Our ref: NO/2023/115288/01-L01
Your ref: 3/2023/0272
Date: 01 June 2023

DEMOLITION OF DETACHED COLLAPSED STORAGE BUILDING AND ERECTION OF ONE TWO-STOREY DWELLING WITH PRIVATE GARDEN AND PARKING AREAS. ERECTION OF A TWO STOREY OUTBUILDING, PROVIDING GARAGE AND HOBBY ROOM SERVING TWINBROOK BARN. TWINBROOKS BARN, UP BROOKS, CLITHEROE, BB7 1PL

Drawing Title
Existing Site Survey Plan showing existing and proposed sections A-A and B-B

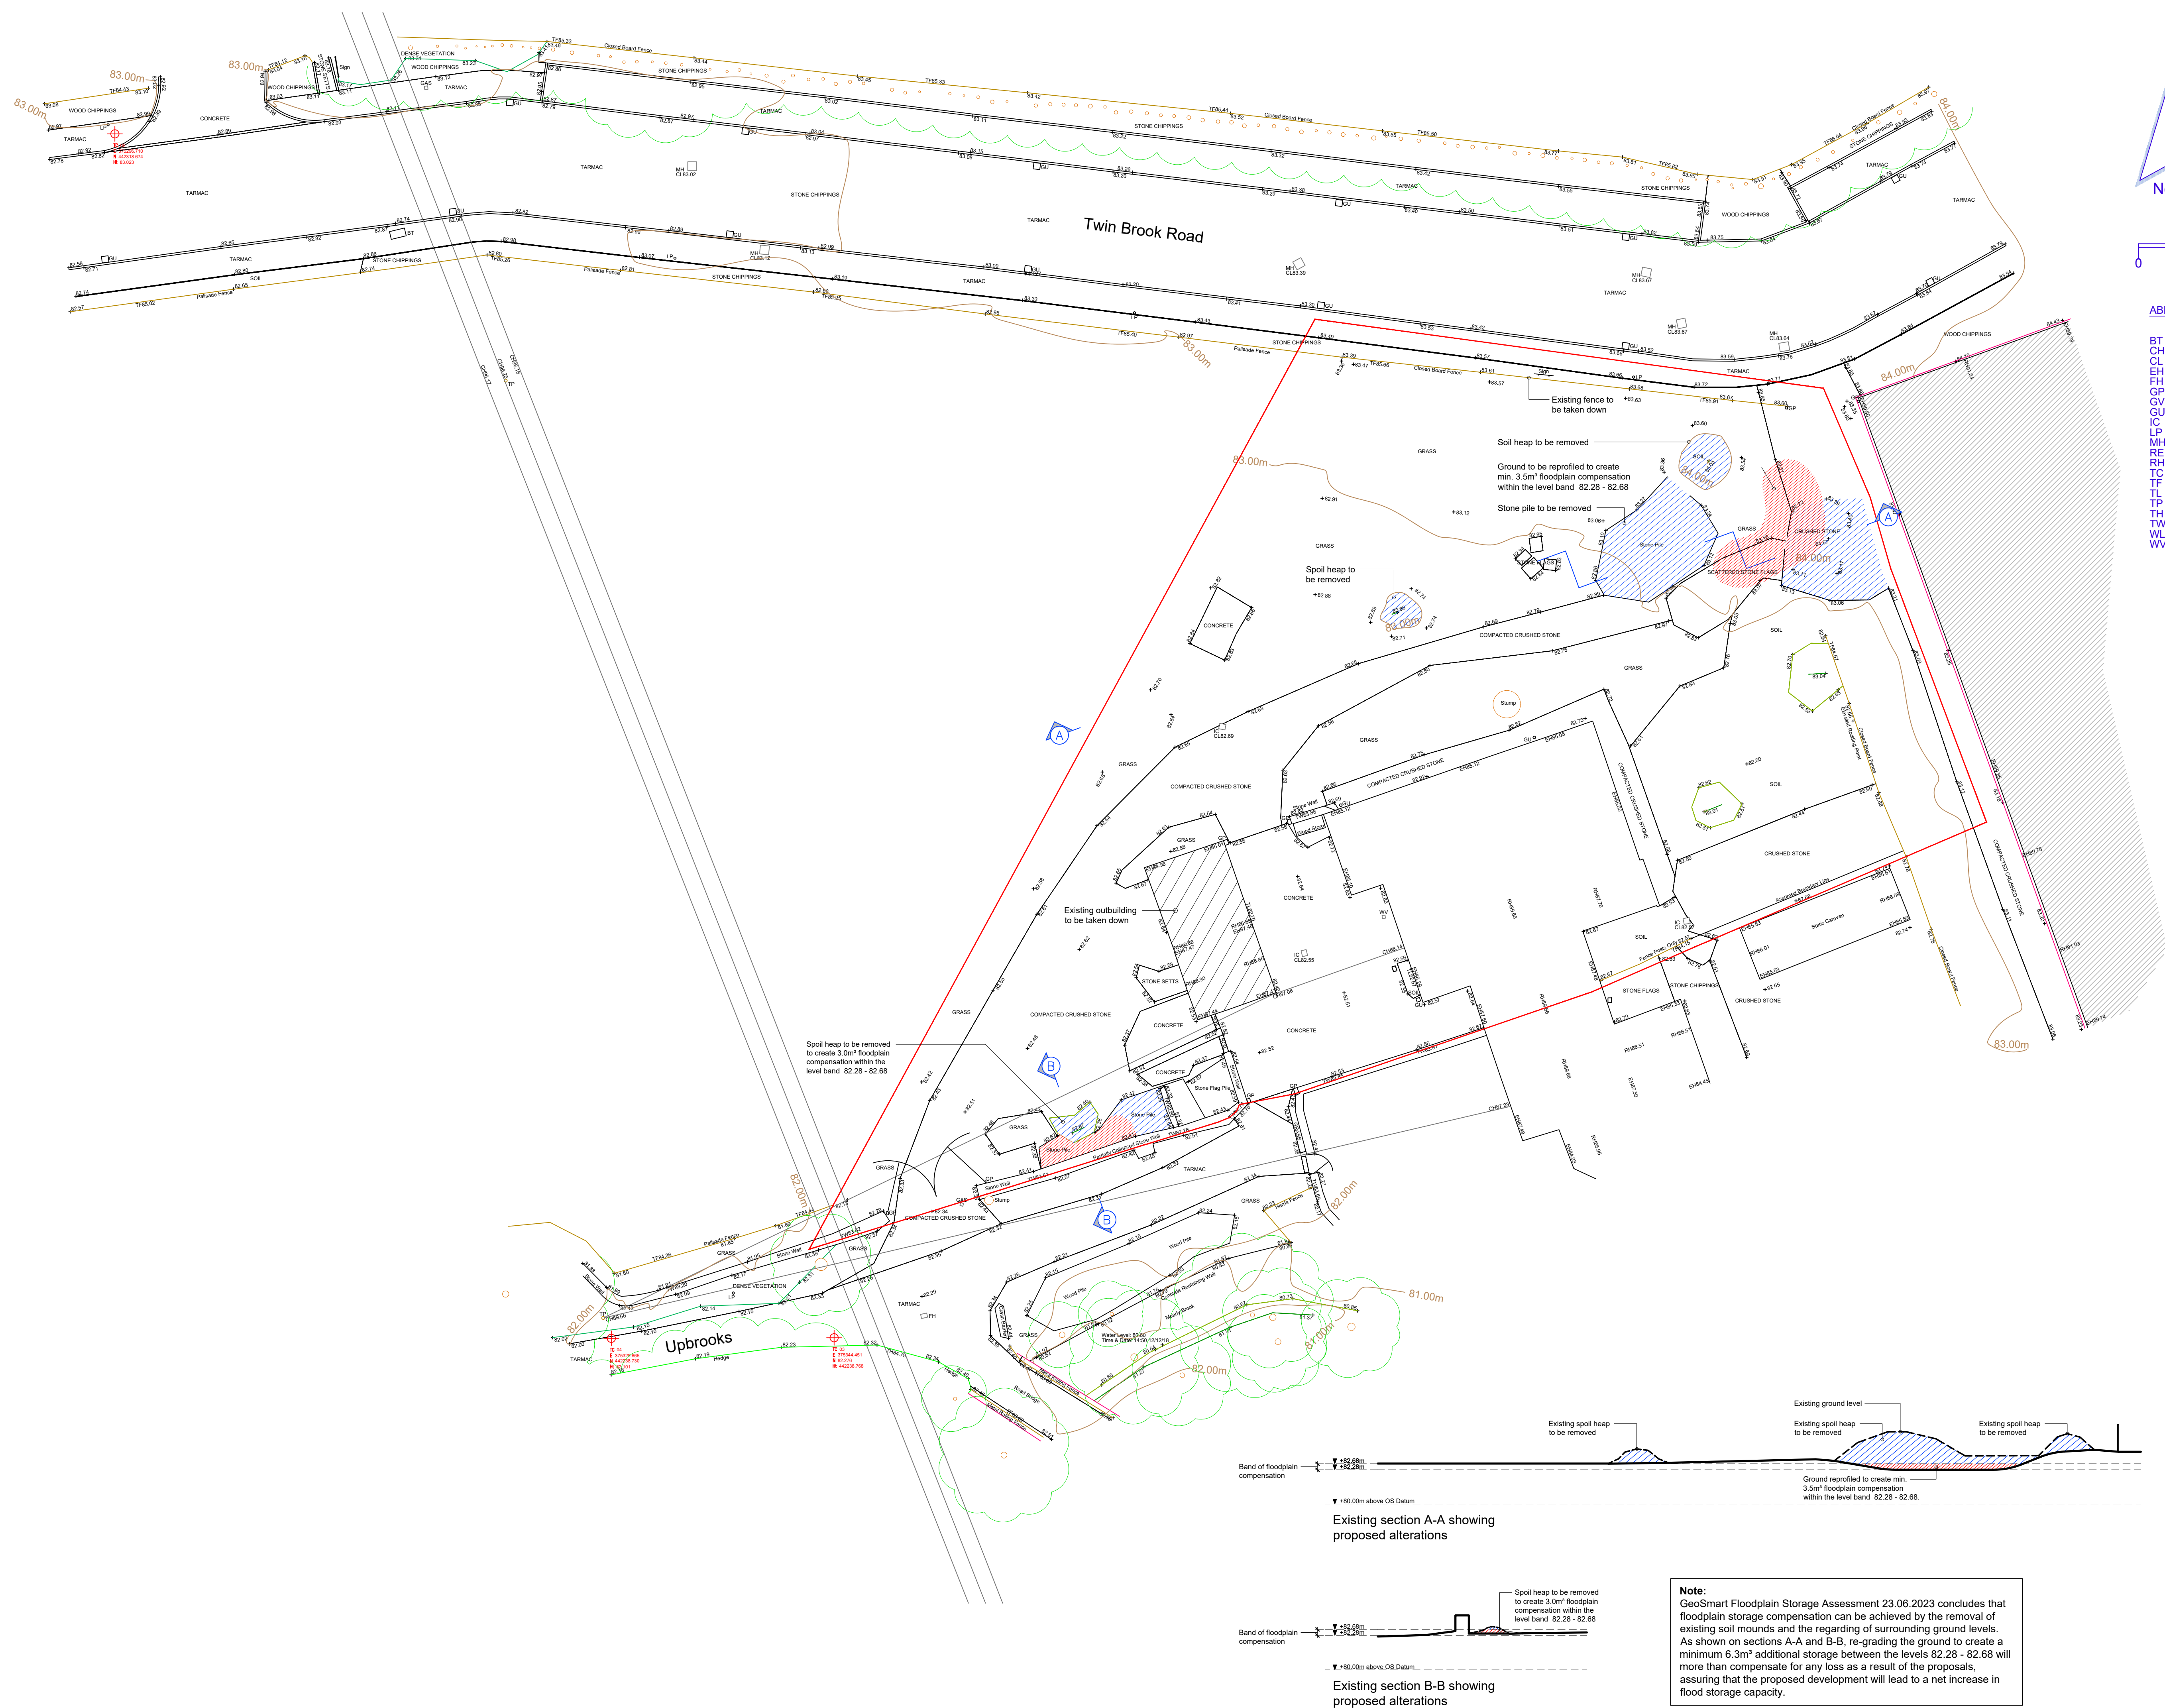
The FRA confirms that; 'As the development proposals involve the increasing of building footprint within the fluvial Flood Zones, compensatory storage will be required, this should be achieved through level for level compensation or where this is not feasible through use of voids.'

No calculation of lost flood plain storage requiring to be compensated for is stated as part of the FRA, and no other proposals are provided in any other supporting documents.

- The FRA proposes inadequate flood storage compensation

Given that the land parcel includes areas of higher ground in Flood Zone 1 and Flood Zone 2, it should be technically feasible to provide level for level compensation. CIRIA 624 (Development and flood risk – guidance for the construction industry - Section A.3.3.10, 2004) states that:

“Compensatory flood storage must become effective at the same point in a flood event as the lost storage would have done (McPherson 2002). It should therefore provide the same volume and be at the same level relative to flood level, as the lost storage”
